**DRB CASE NO/PROJECT NO: 1004873**

Site Plan for Building Permit

DATE: October 9, 2007  
TO: Sheran Matson, DRB Chair  
FROM: Catalina Lehner, Senior Planner   
RE: Project #1004873, Mesa del Sol Community Center Building A

The Site Development Plan for Building Permit (dated September 25, 2007) does not satisfactorily meet the EPC conditions as elaborated in the amended Official Notification of Decision (June 15, 2007) for the following reasons:

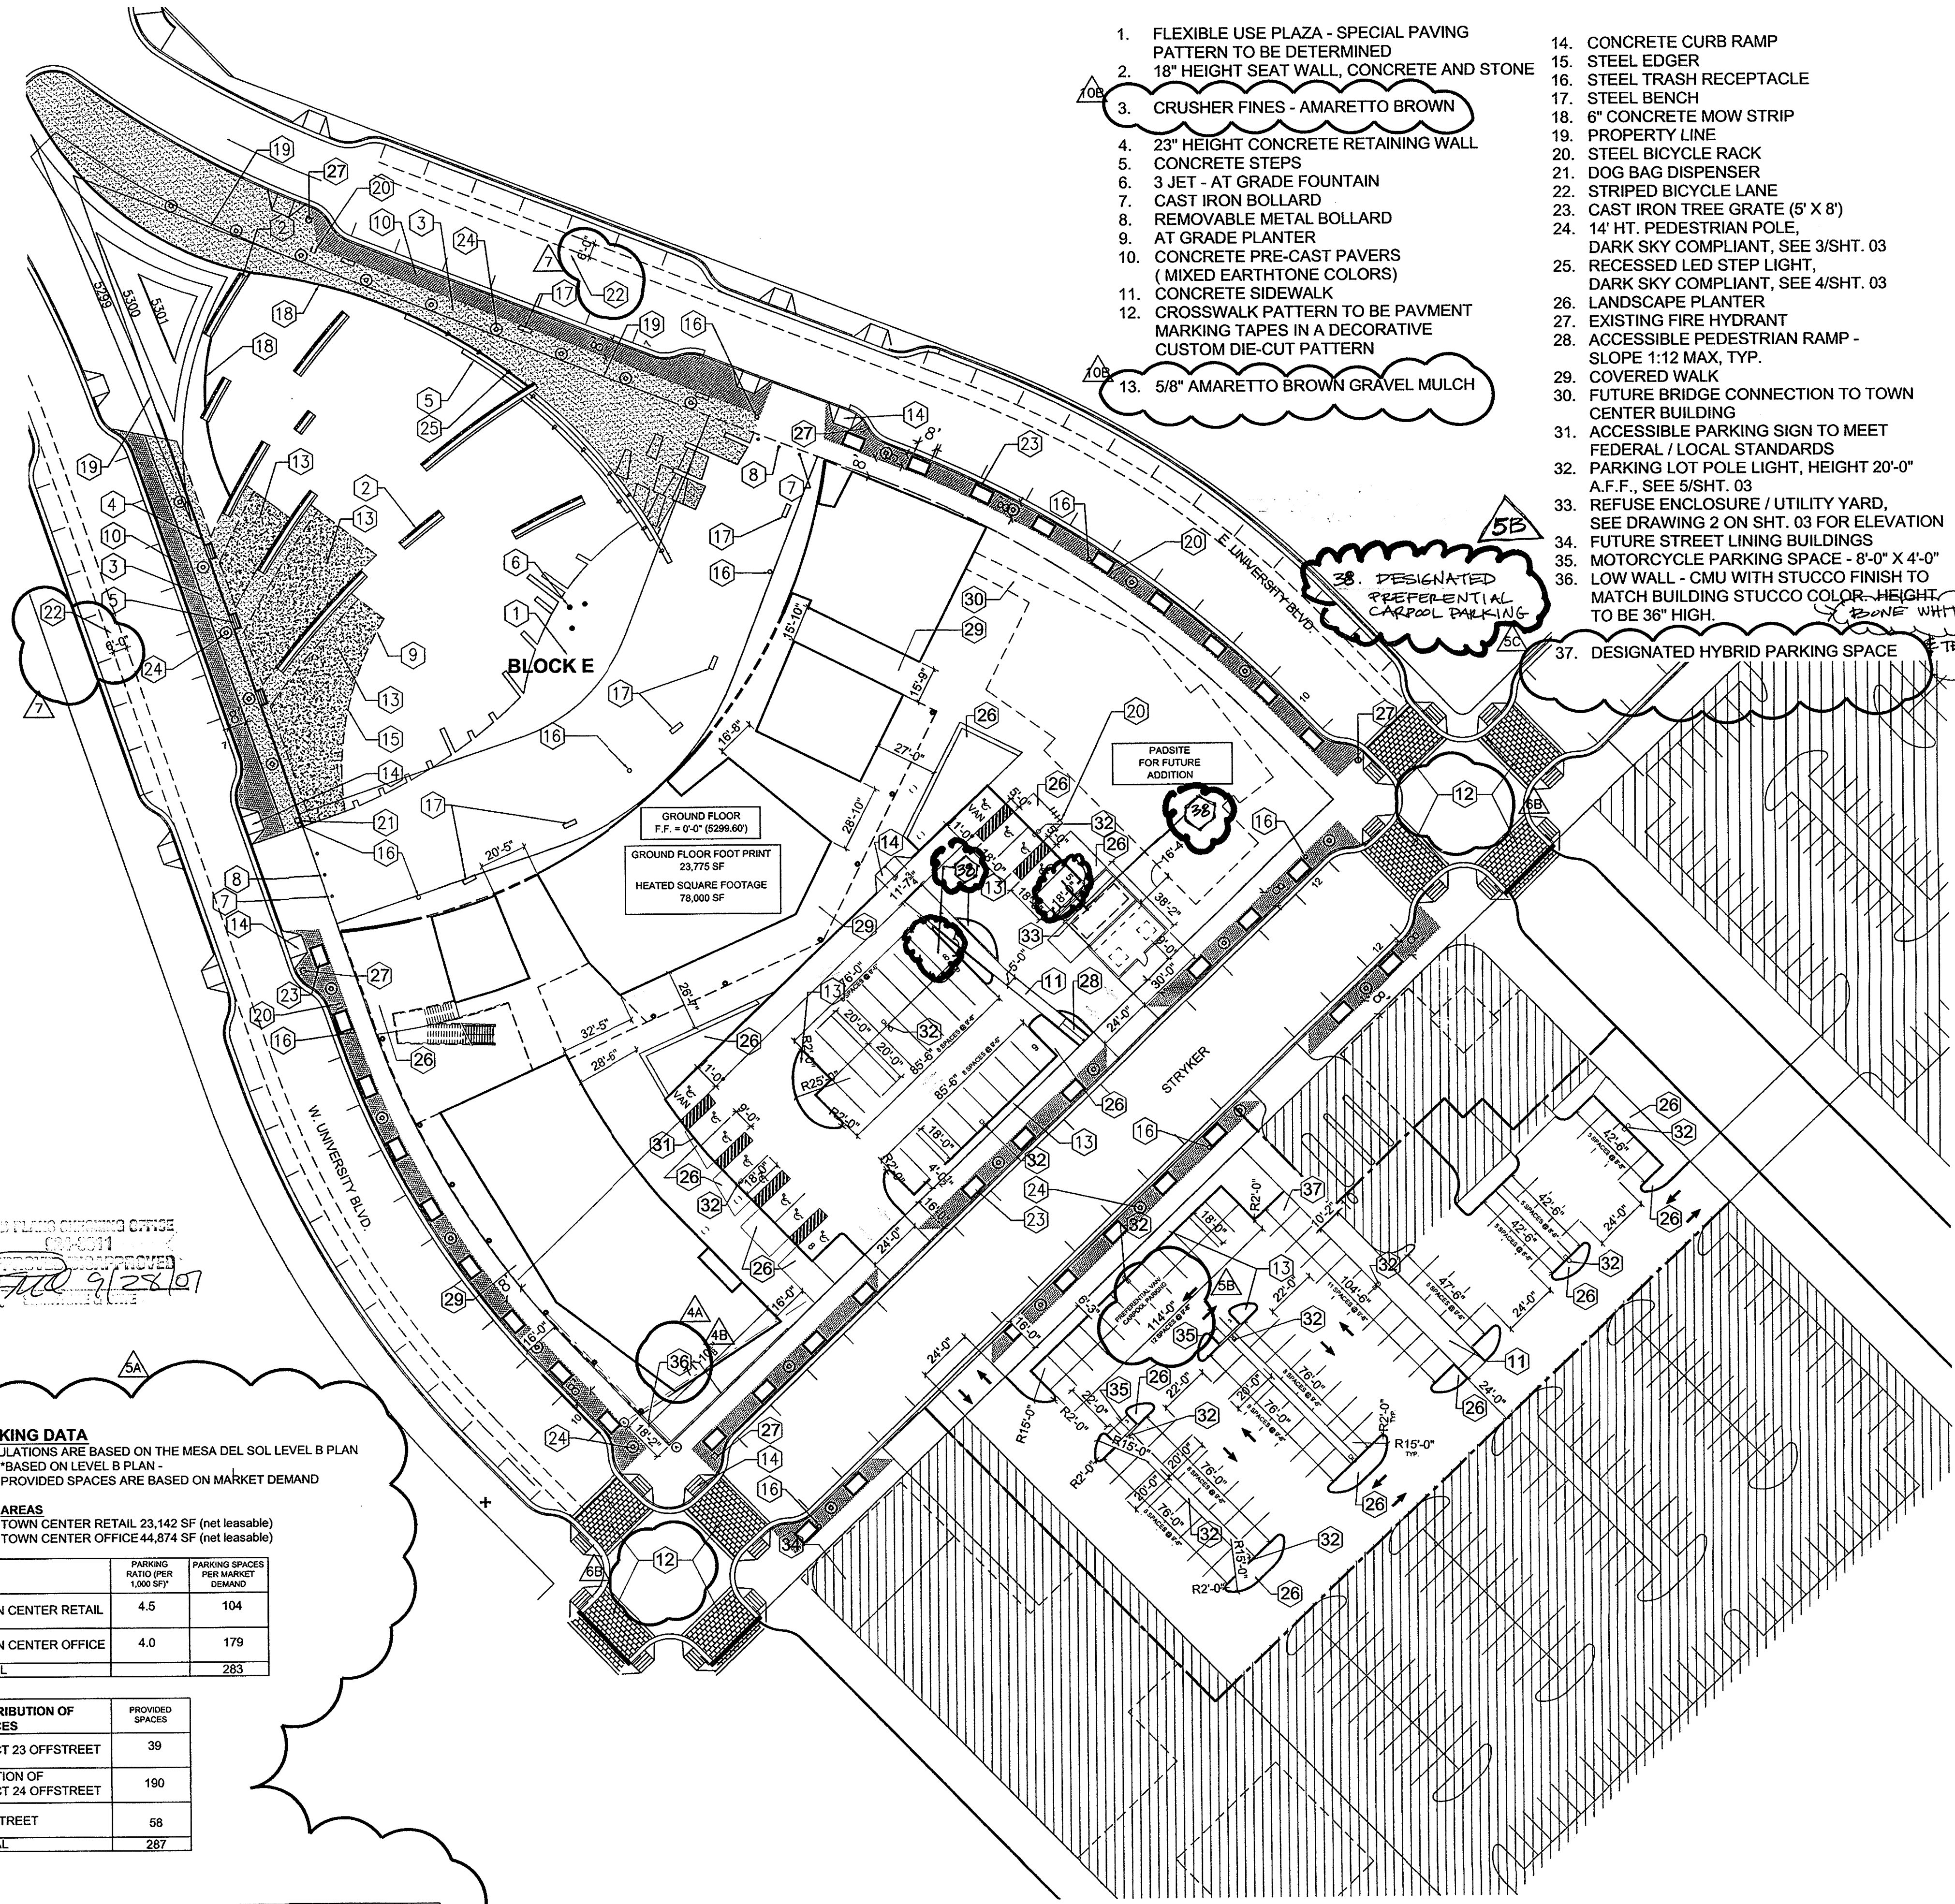
A. The color of the stucco screen wall is not called out. That is “matches the buildings” is not a color name.

B. Staff cannot locate a wall detail, so there is no evidence that texturing has been incorporated into the stucco screen wall. It appears that the wall detail on the previous site plan has been removed.

B. The idea behind preferential carpool parking is that people who are willing to ride with others get the best parking spaces. The van/carpool parking is shown across the way from the main building, too far to be considered a “perk”. Condition 5B will be fulfilled by giving carpoolers spaces in the main parking lot, closest to the building or even on the main lot’s southern side.

C. Staff cannot locate the motorcycle spaces.

D. The idea here, which fits well with the forward-thinking Mesa del Sol, is that landscape islands in parking lots have small cuts in them so water can flow into the landscape (which is flush with the parking lot grade) and provide supplemental irrigation and “clean” the water before it enters the groundwater system. A City parking lot downtown provides an example. There is no evidence on the site plan that this has been done to comply with the condition of approval.

SHEET TITLE:
**LANDSCAPE PLAN
 FOR BUILDING PERMIT**
 SHEET NUMBER:

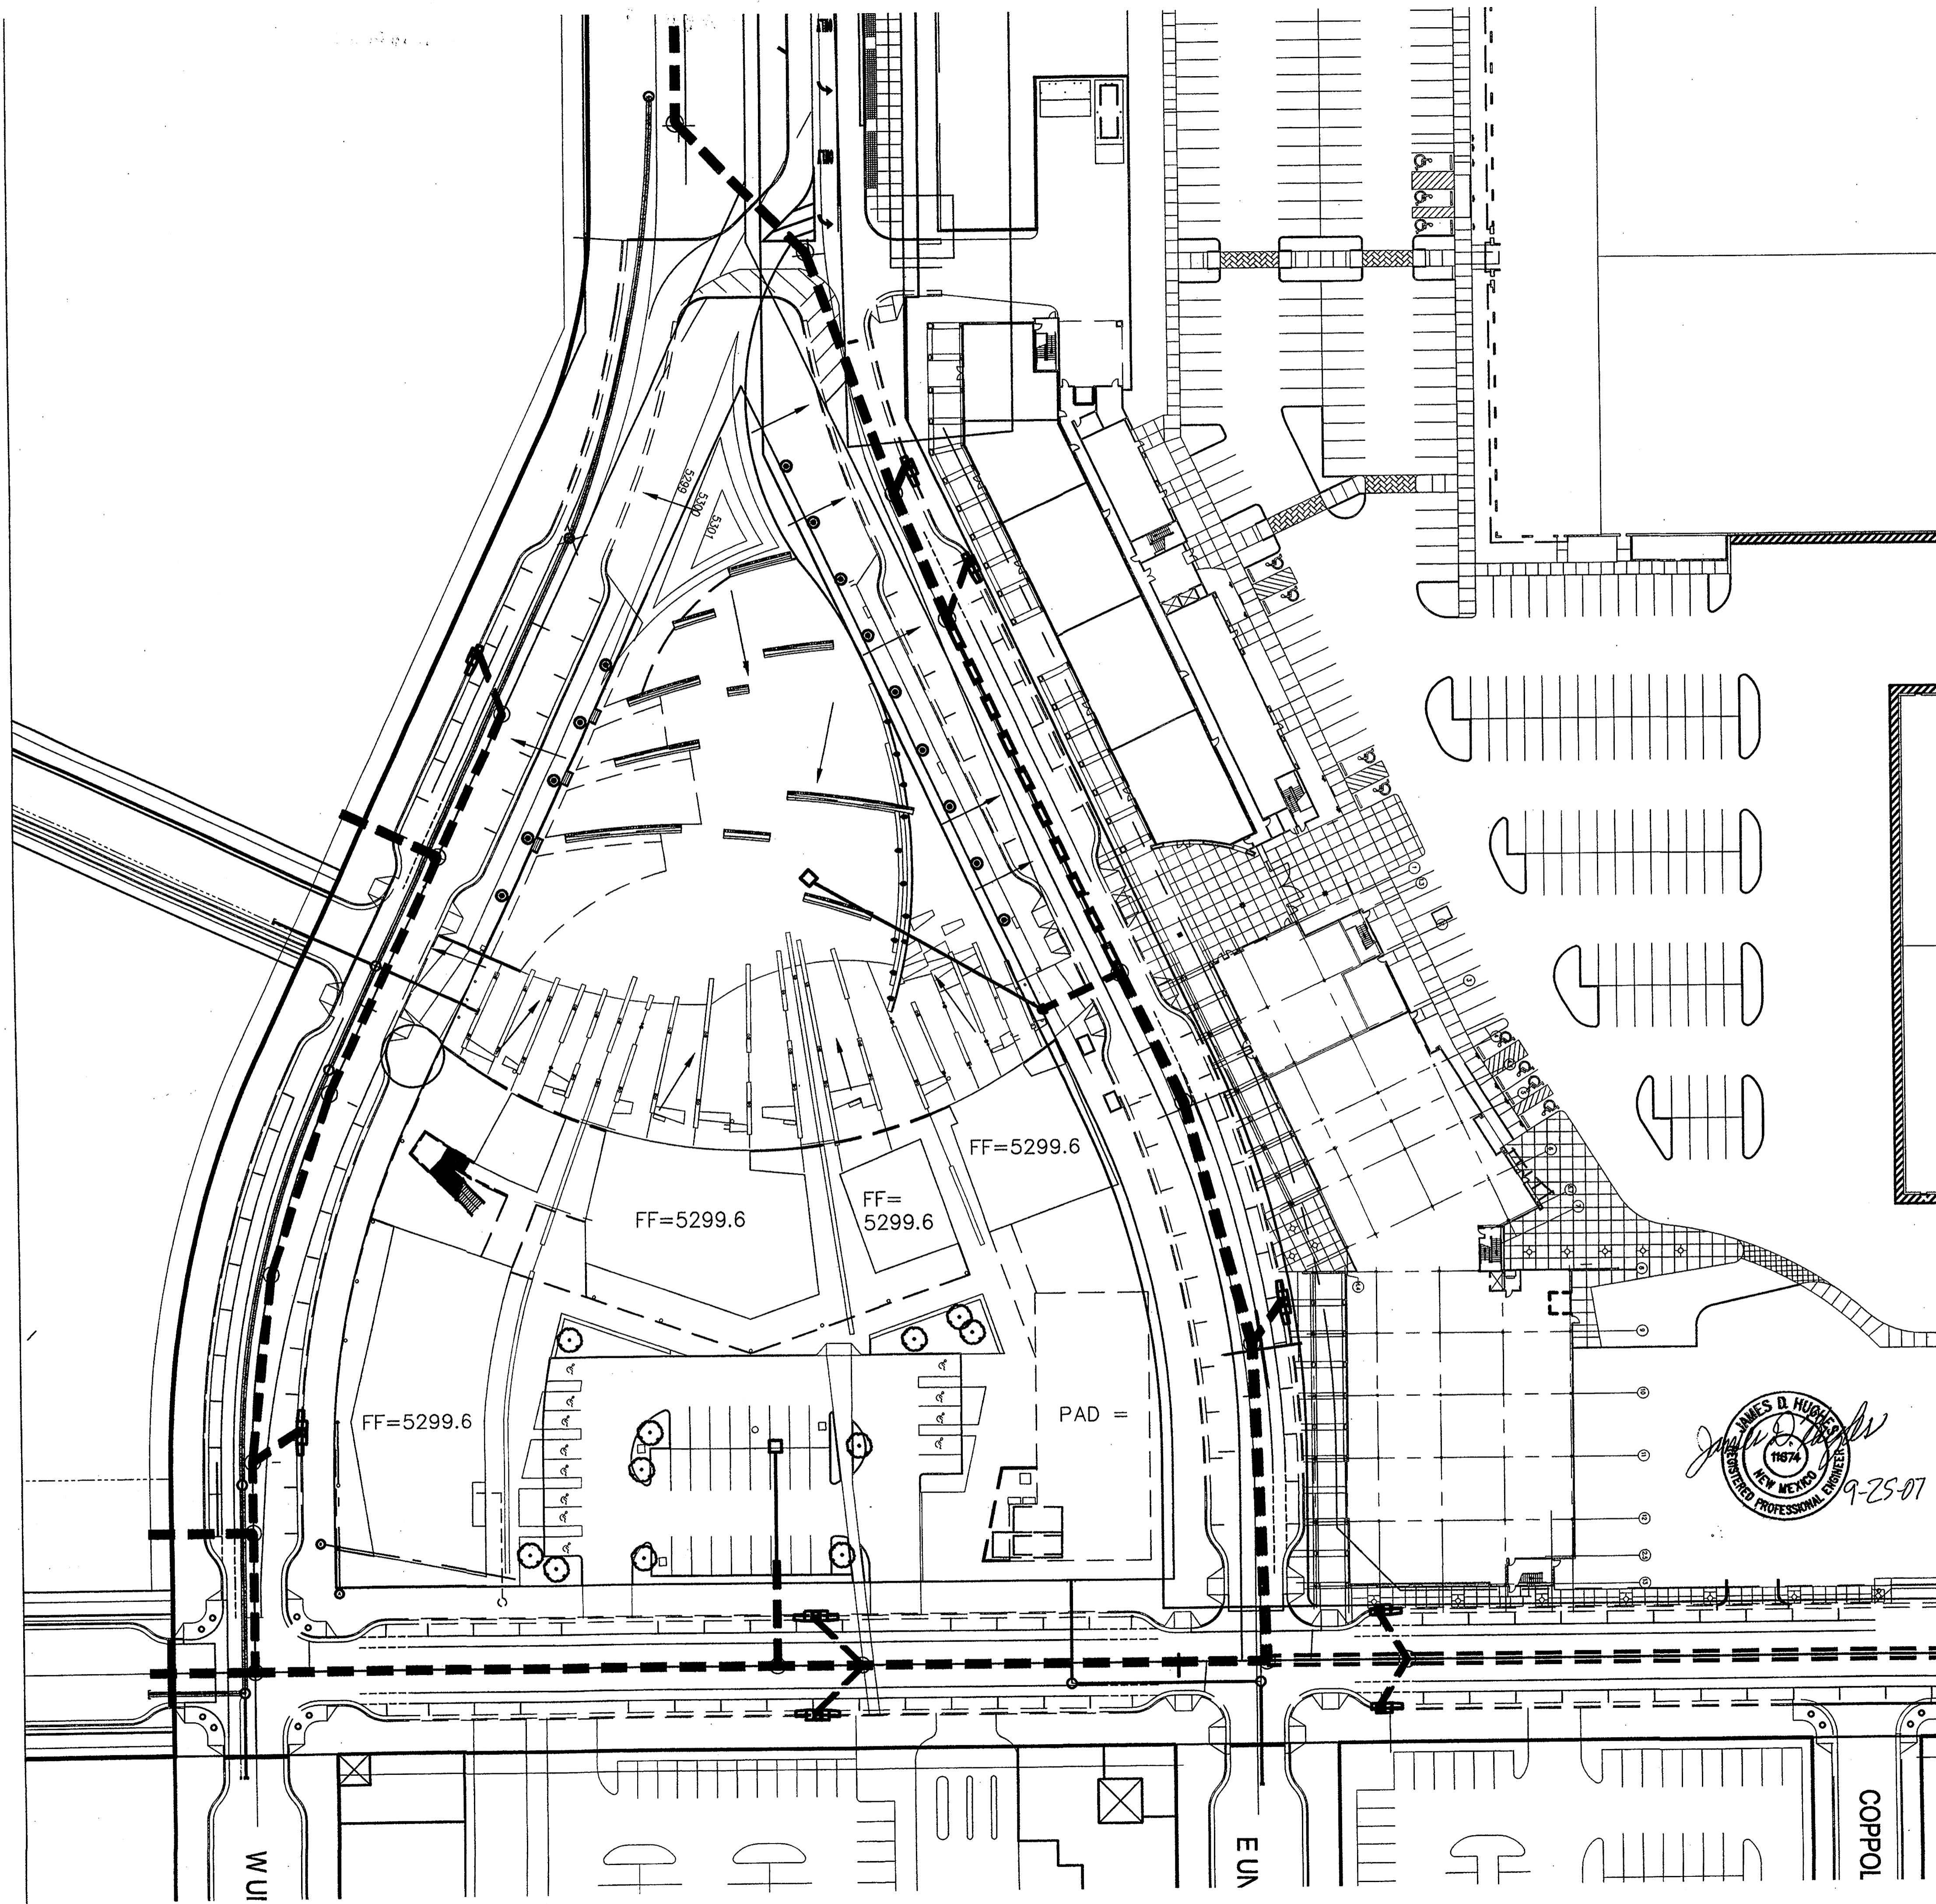
Condition #1: There has been an unauthorized change to the site plan, specifically to the landscaping plan. In the version of the landscaping plan approved by the EPC, the grassy park area was to be covered with "Fescue Blend Sod". The currently proposed landscape plan lists "Kentucky Bluegrass", assumed to be 100% Kentucky bluegrass since no blend is noted. It appears that a different landscape architecture firm is involved. Regardless, this change was not approved by the EPC.

A high-water use turf such as 100% Kentucky Bluegrass does not keep with the City's emphasis on water conservation, much less with the overarching "wise water use" intent of the Mesa del Sol plans. Typically, developments in Albuquerque use a blend (ex. park blend) with up to 20% Kentucky Bluegrass and no more.
